PROJECT NO. PR-2020-003658

Application No. SI-2020-01052 (EPC: SI-2020-00356)

Memorandum

Re: Overture at Andalucia DRB Comment Responses (PR-2020-003658)

L101

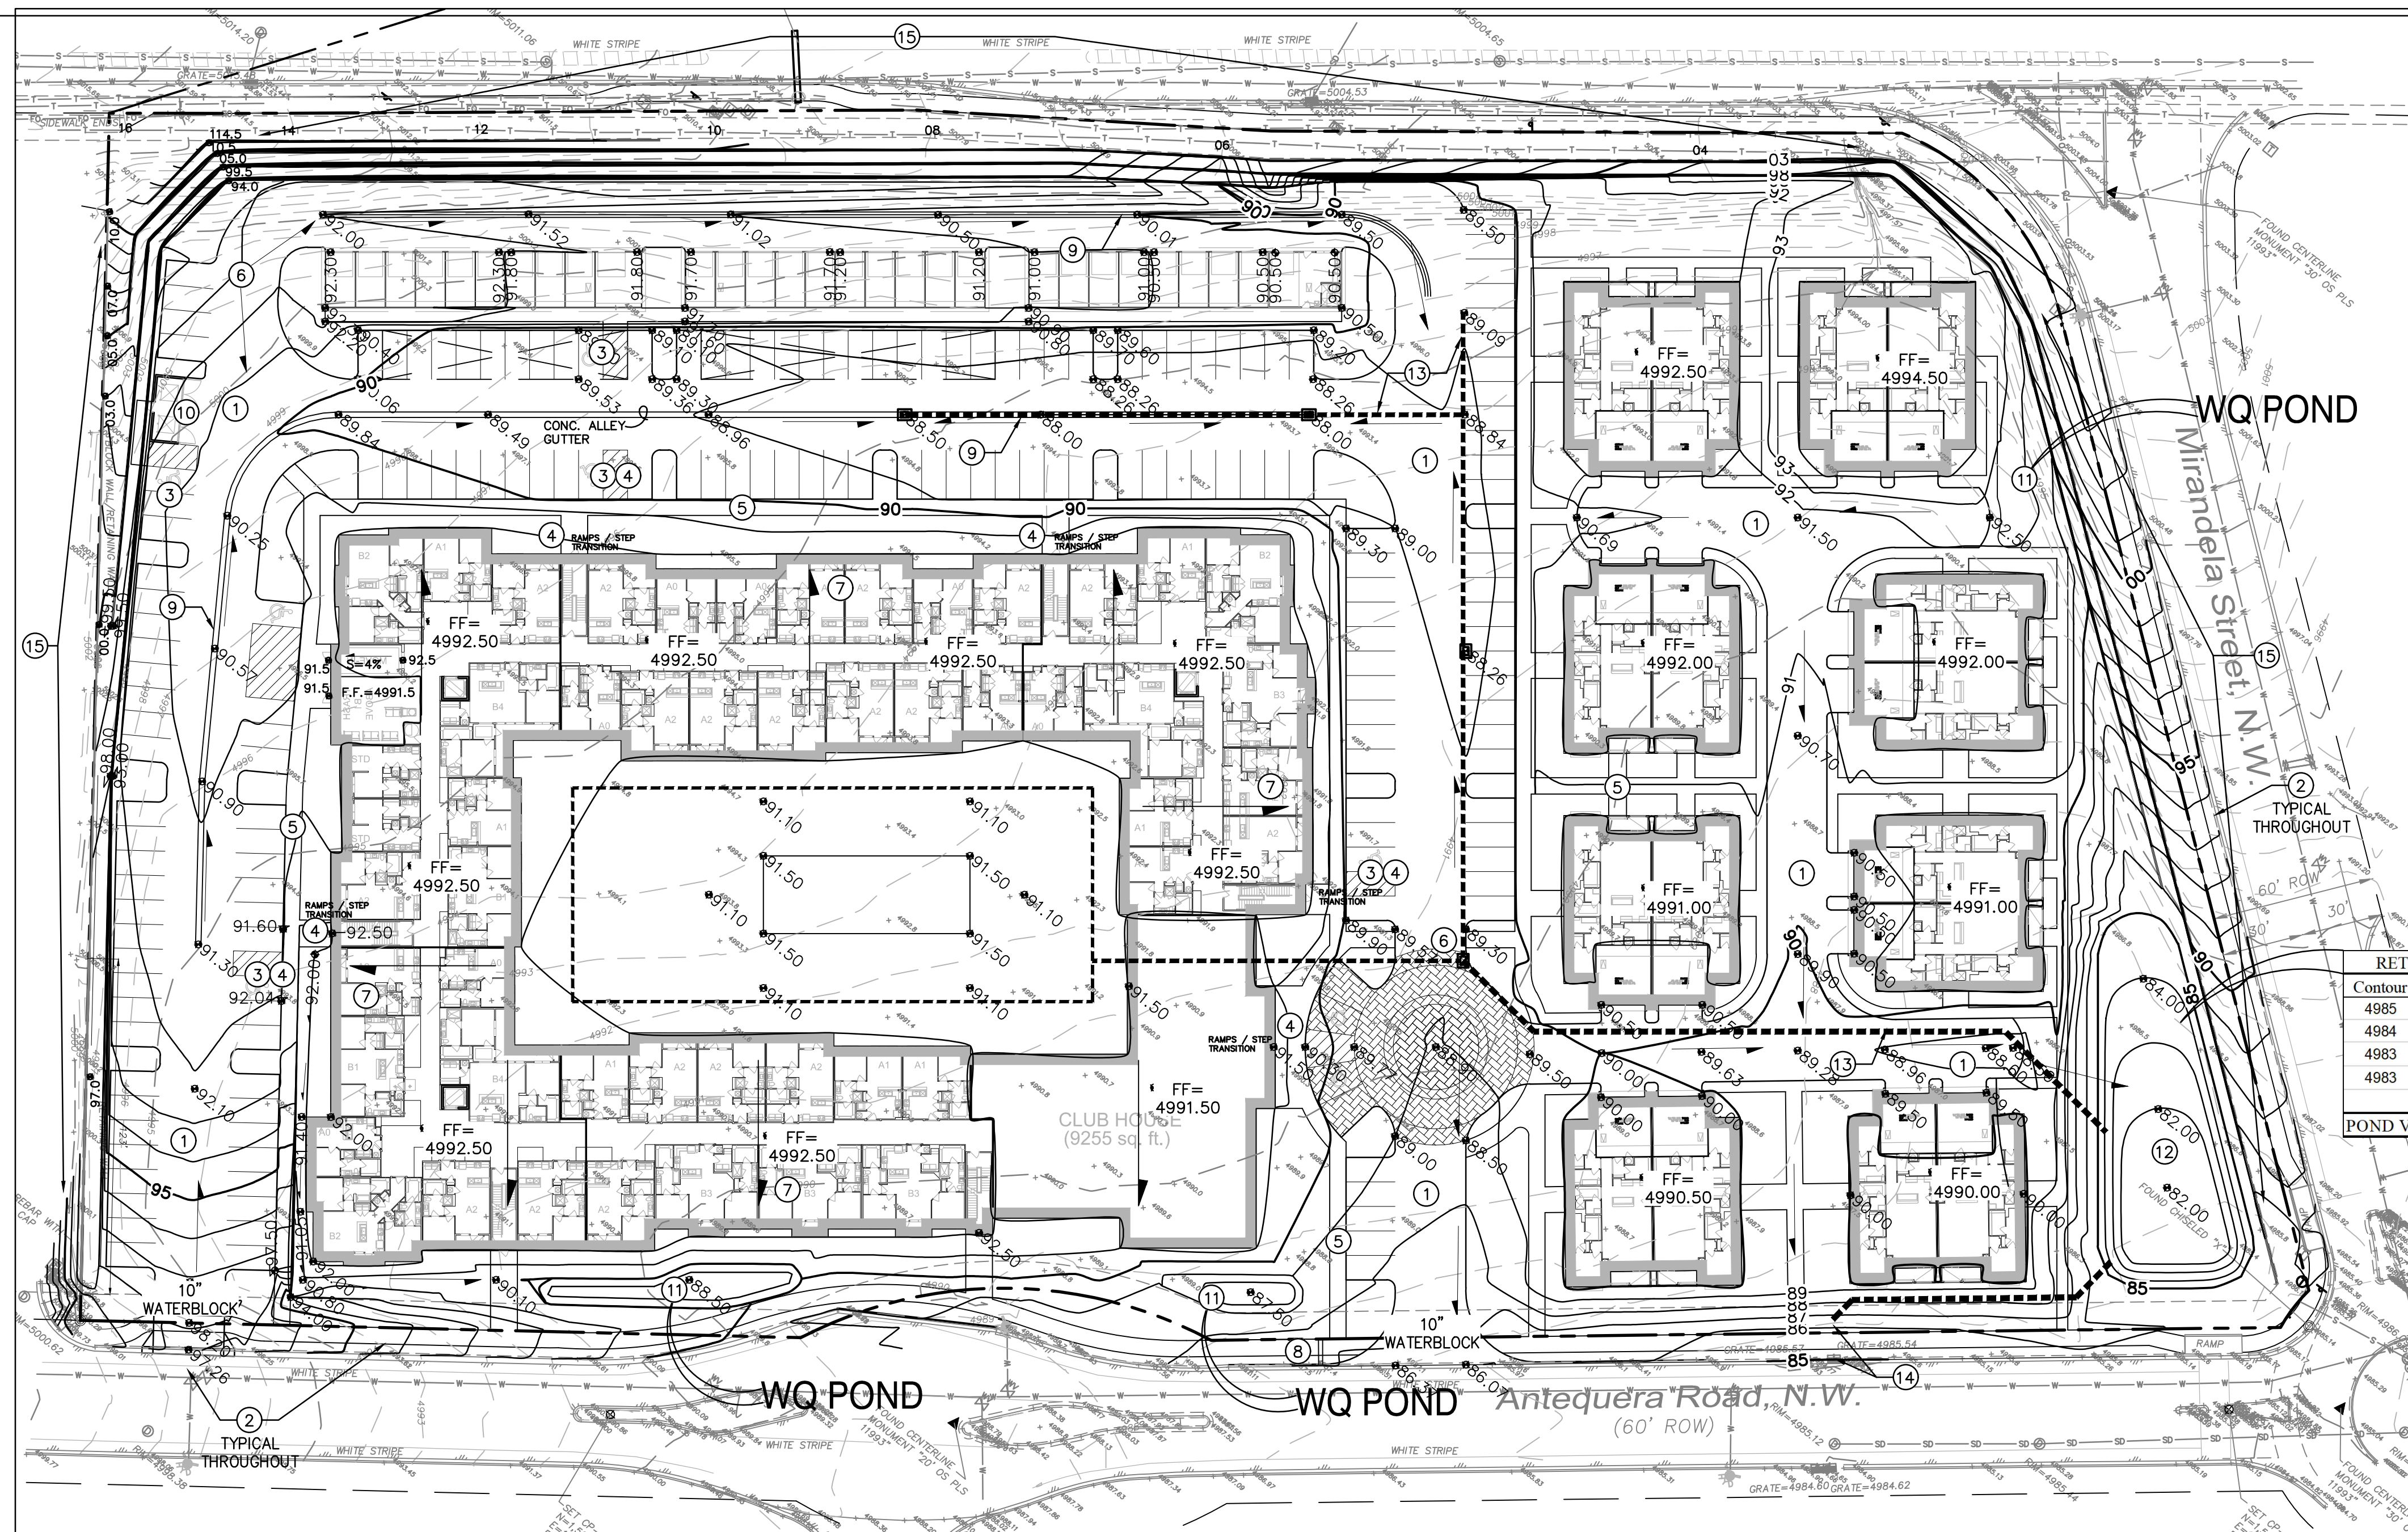
- a. *Language has been added to updated parking sign details.*
- 11. Please add the clear sight triangle to each subdivision entrance on the site plan and on the landscaping plan. Add the following note as well: "Landscaping, fencing and signing will not interfere with clear sight requirements. Therefore, signs, walls, trees, and shrubbery between 3 and 8 feet tall (as measured from the gutter pan) will not be acceptable in the clear sight triangle."

- a. *The sight triangle previously only identified on the landscape plan has been added to the site plan. Site Plan General Note #5 and the Landscape Plan Clear Sight Distance notes have been updated to reflect consistent language as requested.*

SHEET NUMBER
CU-101

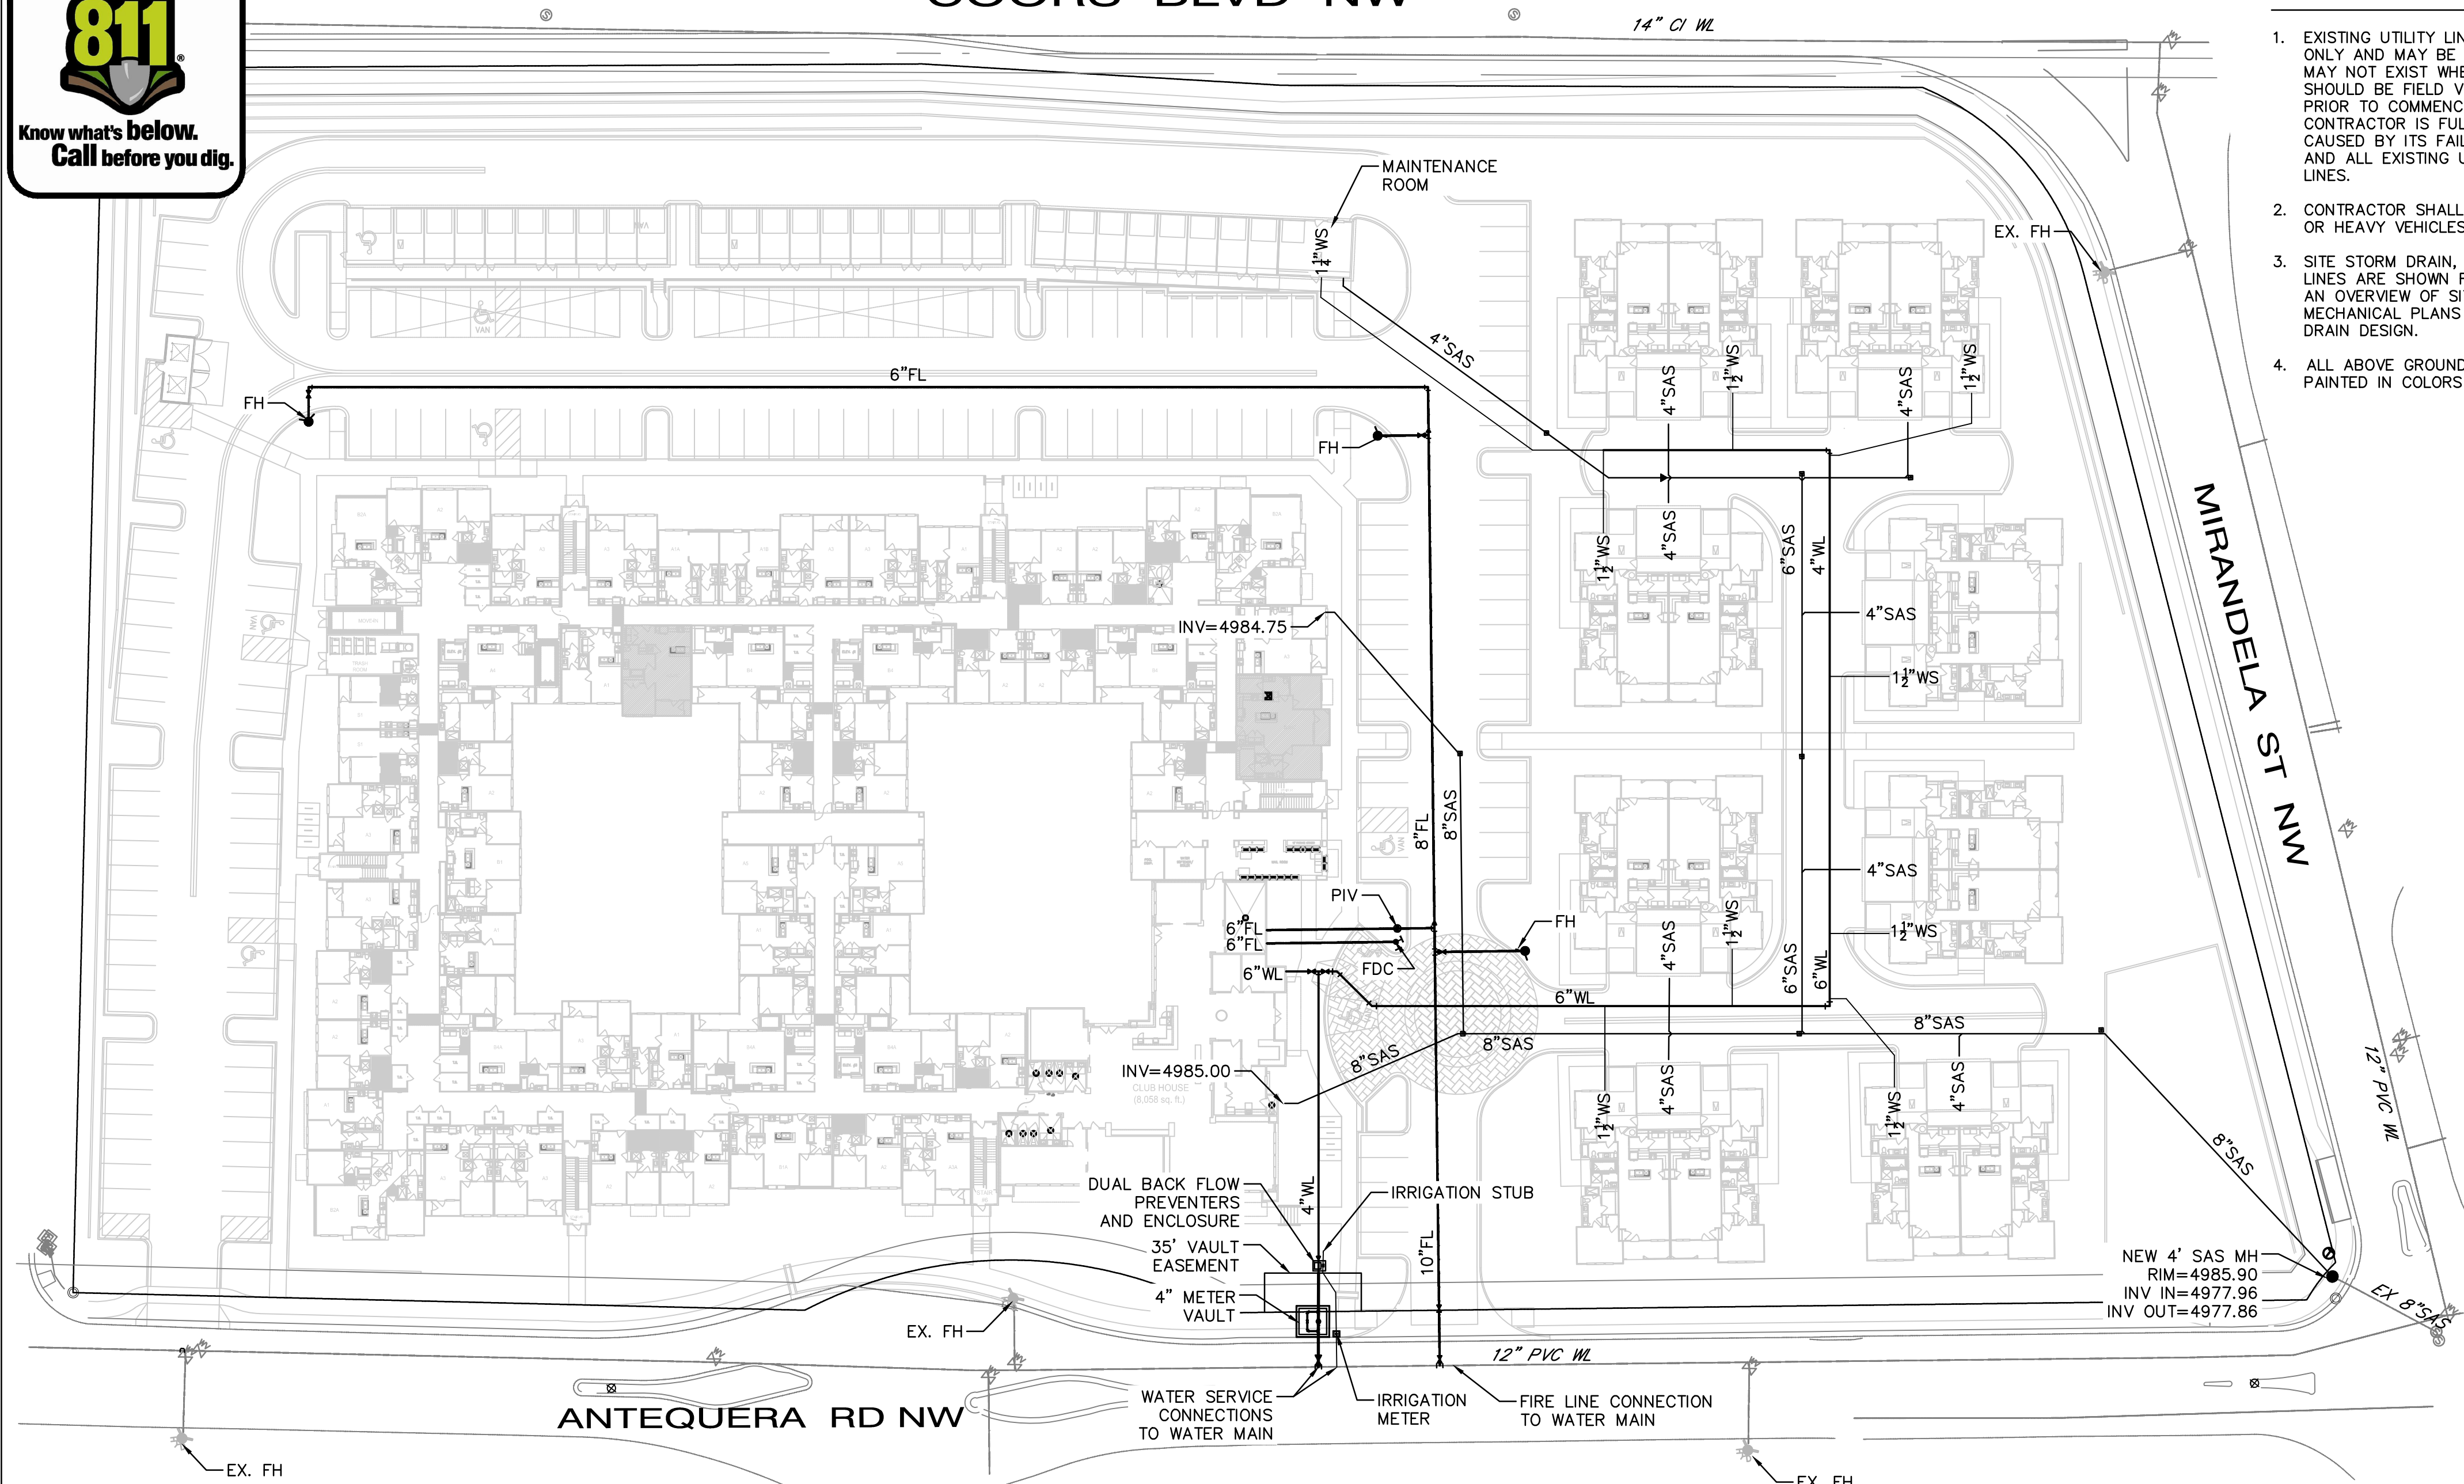
- 1. Availability Statement 200620 provides conditions for service.
 - a. *Understood.*
- 2. Please label all private water and sanitary as private and all public water and public sanitary sewer infrastructure as public.

- a. *Sheet CU-101 has been updated to reflect all utilities as public or private.*
- 3. The new manhole proposed on the site utility plan should be labeled private and within the property.

- a. *The manhole is identified on the updated utility plan as private.*
- 4. Records indicate there is a ten-inch waterline along Antequera Rd. and Mirandela St., please confirm and adjust site plan accordingly.

- a. *The plan has been updated and adjusted to reflect an existing 10" waterline.*
- 5. For the site plan the backflow preventer called out is dual backflow preventers as noted. Please clarify this is for both services and not the type. Reduced pressure backflow preventers are typically required for containment and to be coordinated with Water Authority Cross Connection Section.

- a. *This is clarified on the utility plan as "domestic & irrigation back flow preventers."*
